21/03350/TEL and 21/03452/TEL56 – comments from Kirtlington Parish Council

Proposed 5G Telecommunications Installation for H3G at Station Road, Kirtlington

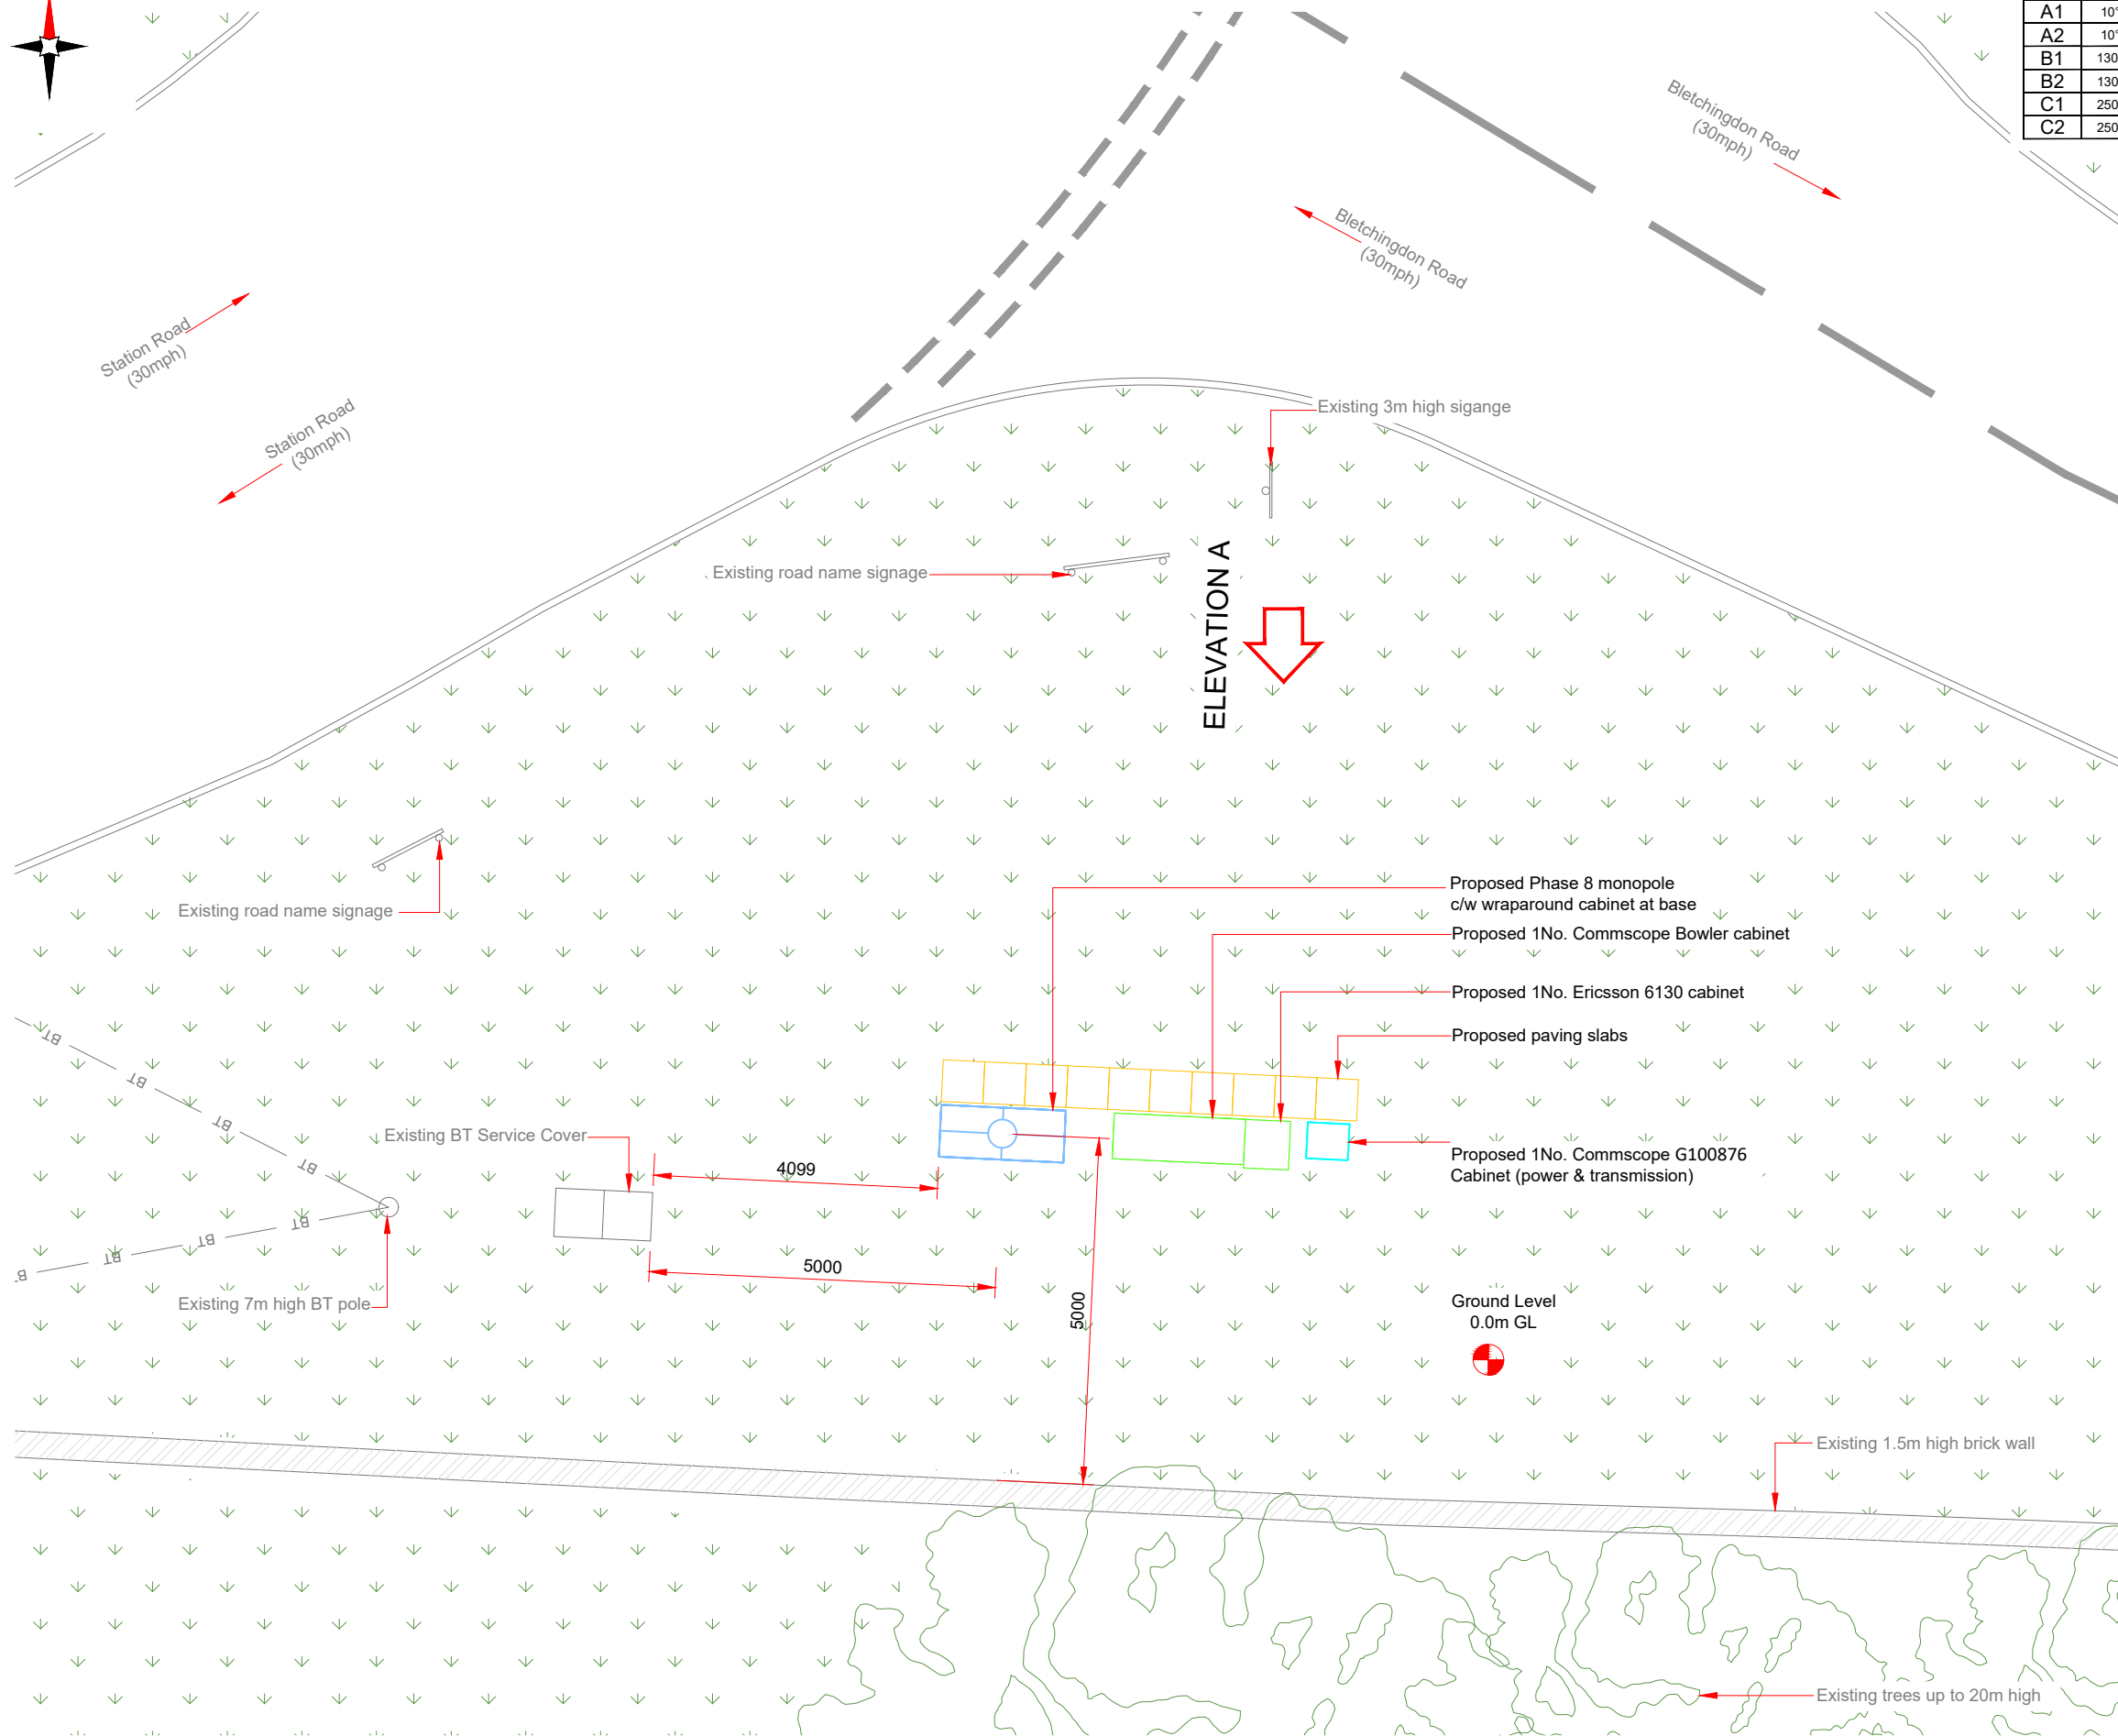
The location of the site is a wide grass verge (in the ownership of the Highway Authority - Oxfordshire County Council) within the south-western edge of the Kirtlington Conservation Area (refer to Kirtlington Conservation Area Appraisal (CAA) by Cherwell District Council, September 2011). The site is a visually prominent position at the junction of three main approaches at the southern end of Kirtlington:

This broad junction has a generally open character, created by the wide, grass verge upon which the mast is proposed, and when this is combined with the large area of grass verge on the north side of Station Road, the area has a sense of openness that is as important in defining the character of the village as are the North and South Greens. It is considered that, other than positioning the proposed mast on the Greens, a more visually intrusive location for this development would have been difficult to find.

- a) The garden of Willow Tree Barn lies immediately to the south of the verge, with the residential property located 37m from the proposed mast;
- b) Stoney Crest, to the east of the mast site, and 63m from the proposed mast;
- c) Troy House, (former Vicarage), 46m to the north-east of the proposed mast;
- d) Red Rose Cottage and No 2 Troy Lane, 57m to the north of the proposed mast;
- e) Nos 2 and 3 Turnpike Cottages, 49m to the north-west of the proposed mast;
- f) Rosemount, 56m to the north-west of the proposed mast.

If permission for the proposed mast were granted in the applicant's preferred location, then KPC requests that the cabinets are screened by placing them in a stone walled enclosure, built parallel to the existing retained stone wall. Such mitigation would be supportive of Policy PD5: Building and Site Design of the Mid-Cherwell Neighbourhood Plan. In addition, this verge, up to a few years ago, was the location of a fine mature False Acacia, which unfortunately died, therefore it is requested that a native species tree, of ultimately similar stature, should be replanted in its place, to help mitigate the visual intrusion of the mast on this sensitive location in the village.

Title: **260 PROPOSED ELEVATION**

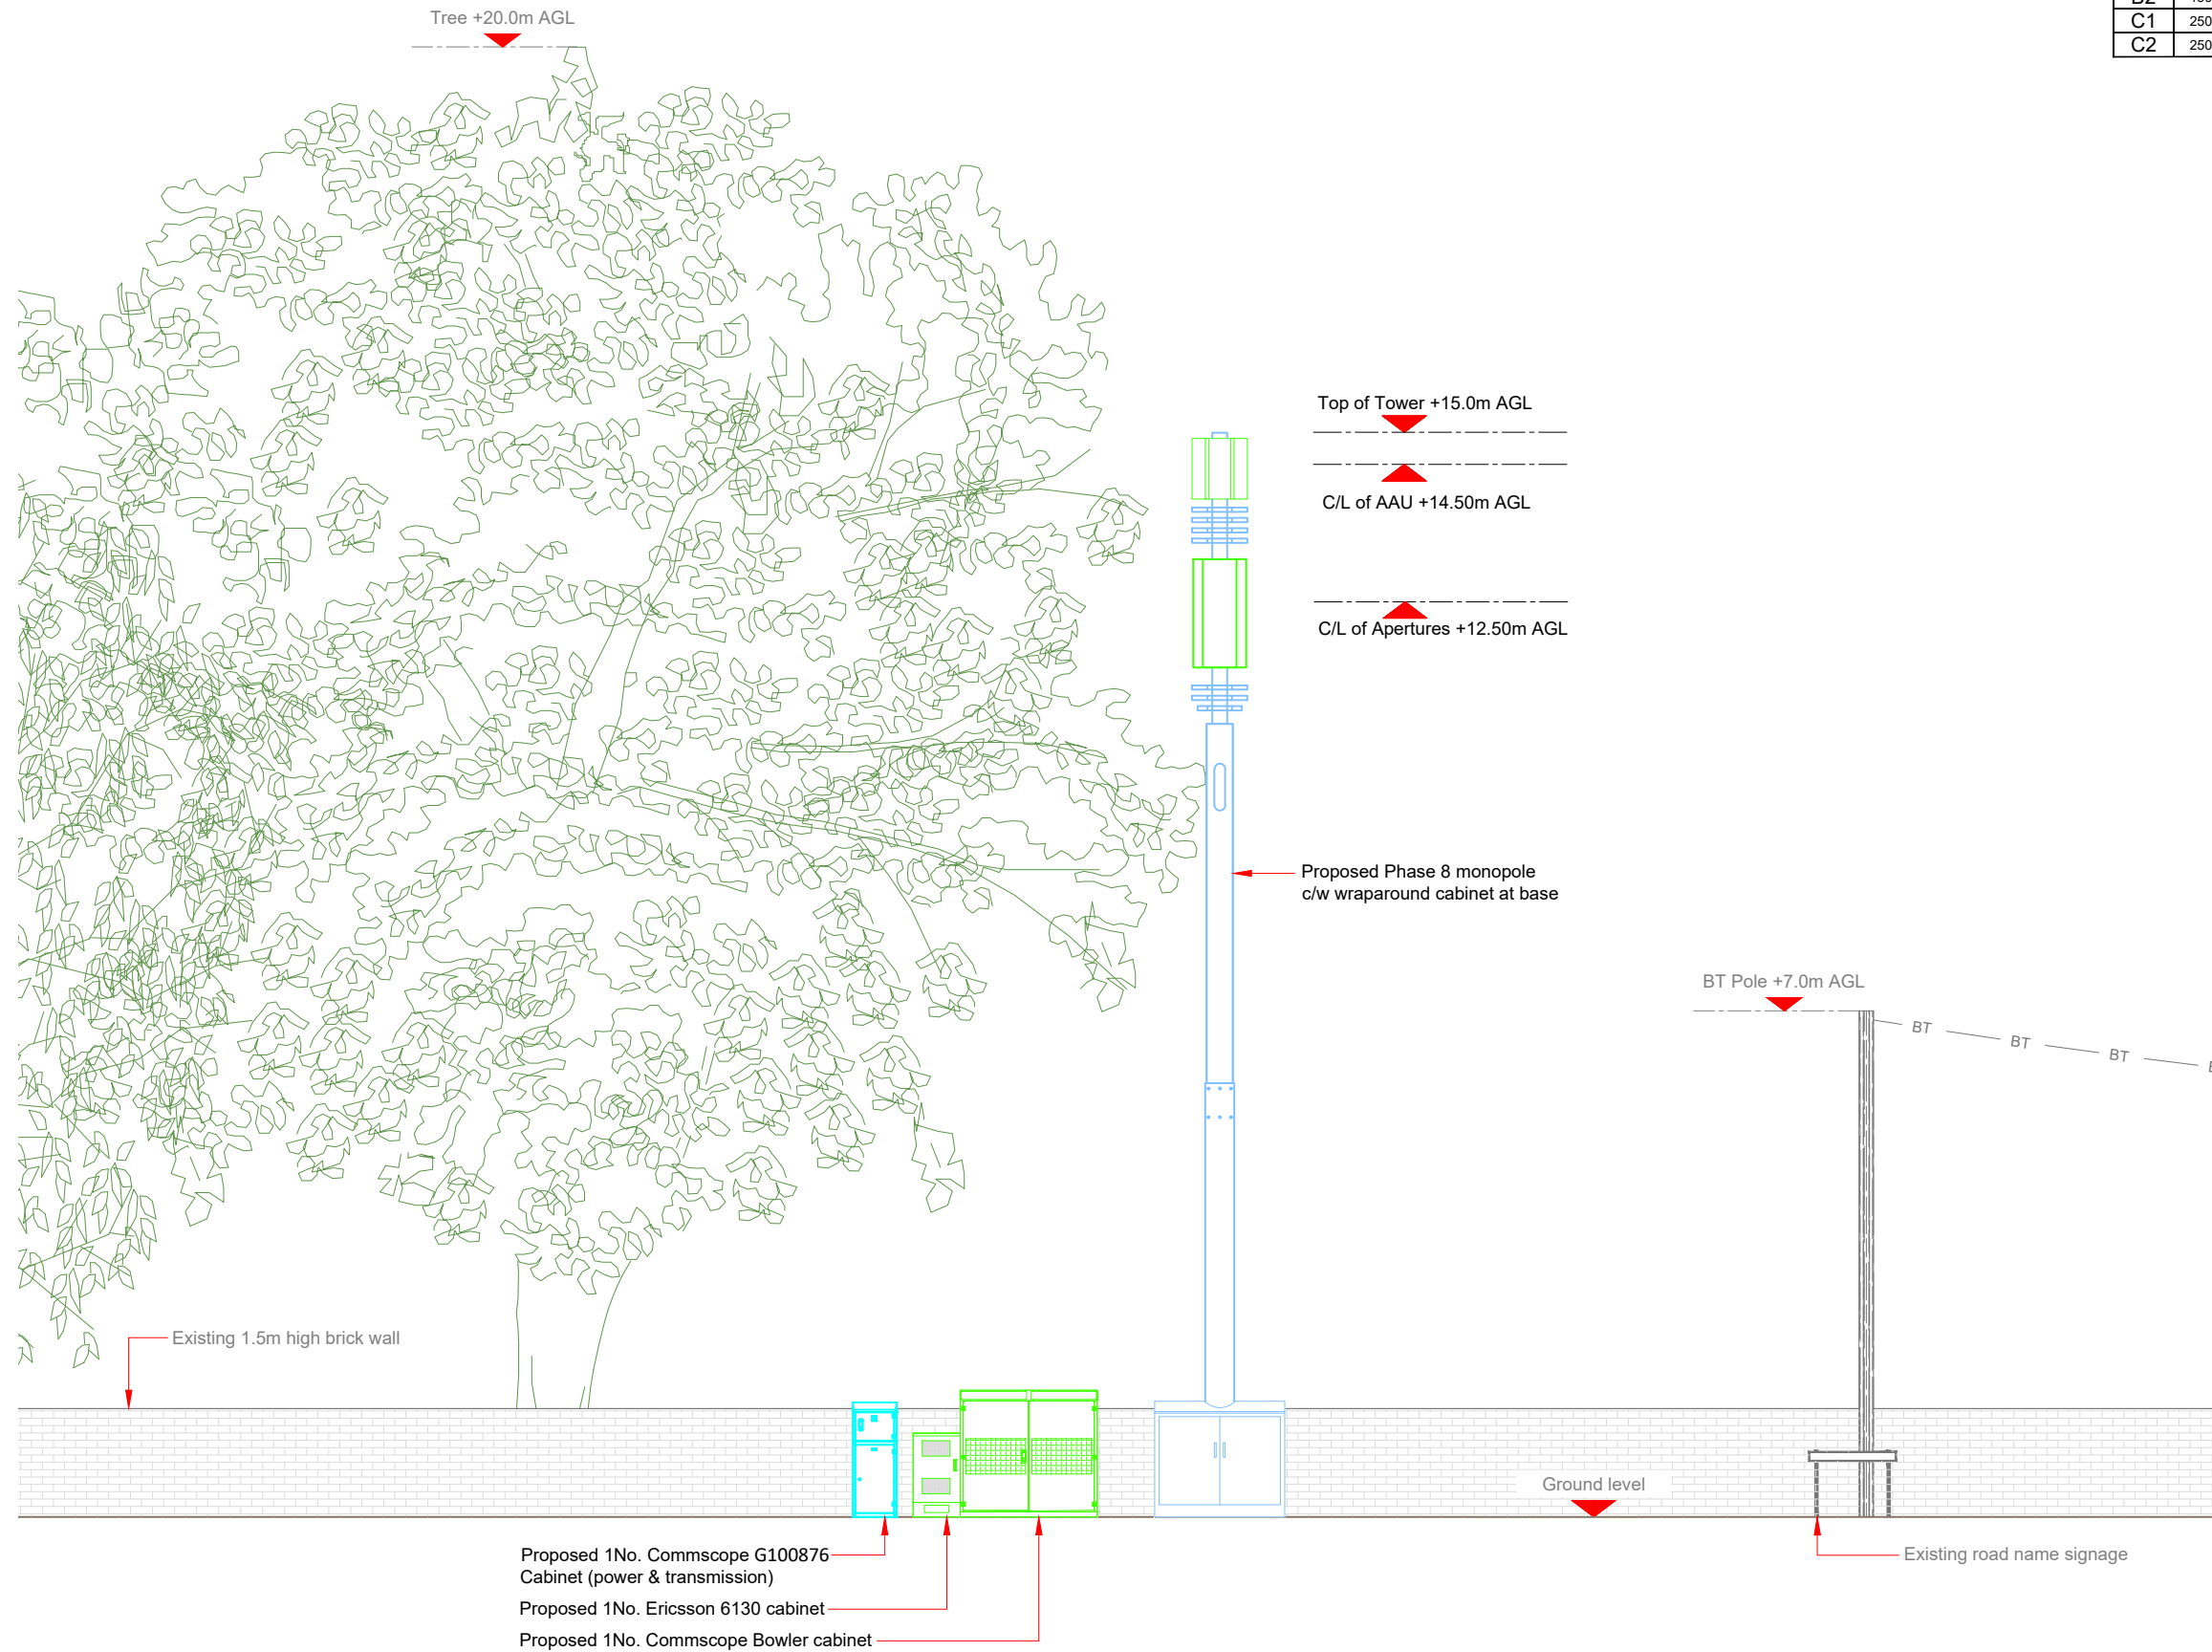
Kirtlington Parish Council would like to support the operator's roll out of the 5G network, but the location for this proposed 15m high monopole and its four associated cabinets is so ill-conceived in terms of its siting and appearance and the adverse effect that this development would have on the character and appearance of the village, that it feels compelled to strongly object to this application.

At 15m in height the proposed monopole would be significantly higher than the limited items of nearby street furniture, which includes a wooden BT pole at 7m high, a give-way sign and two low-level street name signs. There are no streetlights at this end of the village (again, contrary to what is stated in the SSSI). In the absence of any other structures of comparable height in the immediate vicinity, the development, including the clutter of the four associated cabinets, would be visually intrusive and introduce incongruous features within the street scene which would diminish the existing pleasant character and attractiveness of the Conservation Area.
